Harnett County
420 McKinney Pkwy

SUBJECT: SFD2205-0065
SINGLE FAMILY DWELLING

Here are the results of all Inspections located at **159 HAY FIELD DR:**

Job 22030102-A	Truss A02	Truss Type Piggyback Base	Qty 4	Ply 1	100 Farm at Neills Creek-Cooper 4-Roof	I57729103
					Job Reference (optional)

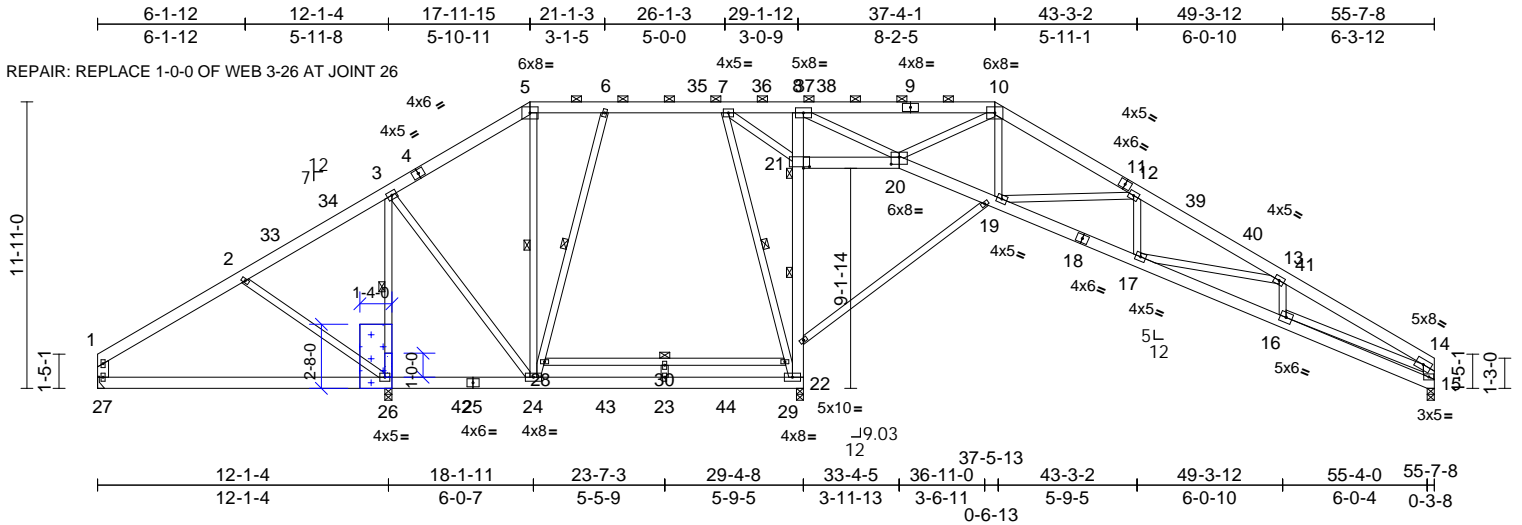
Inspection Type: FINAL SFD MONO**
Scheduled Date/Time: 4/10/2023
Completed Date/Time: 4/10/2023
Inspector: Justin Ryan McLeod
Result: DISAPPROVED
Remarks:
Notes: Truss broke at attic access, need repair

Job 22030102	Truss B01	Truss Type Piggyback Base	Qty 4	Ply 1	DRB - 100 FARM AT NEILLS CREEK Job Reference (optional)	I51256990
-----------------	--------------	------------------------------	----------	----------	------------------------------------------------------------	-----------

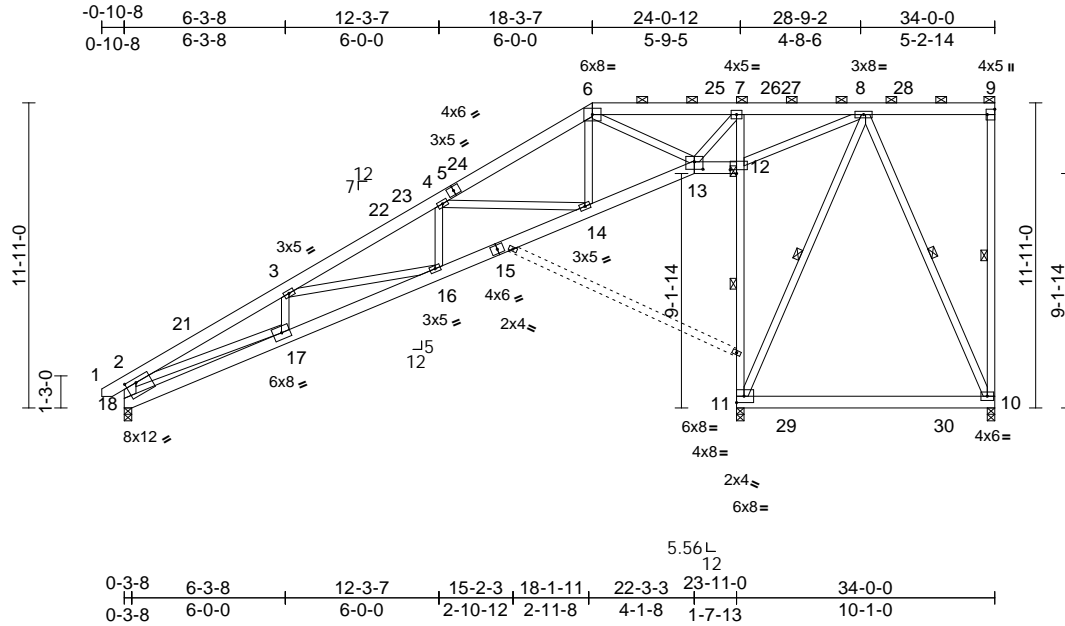
1. Need enough for anchor bolt in front bedroom. 2. Strap header above front bedroom on right side. 3. Block all air barriers at top. 4. Need engineer letter where three studs were over bored in master bedroom for plumbing. 5 Fire block top of pantry at ceiling level. 6. B2 trusses missing web bracing. OK to side insulate
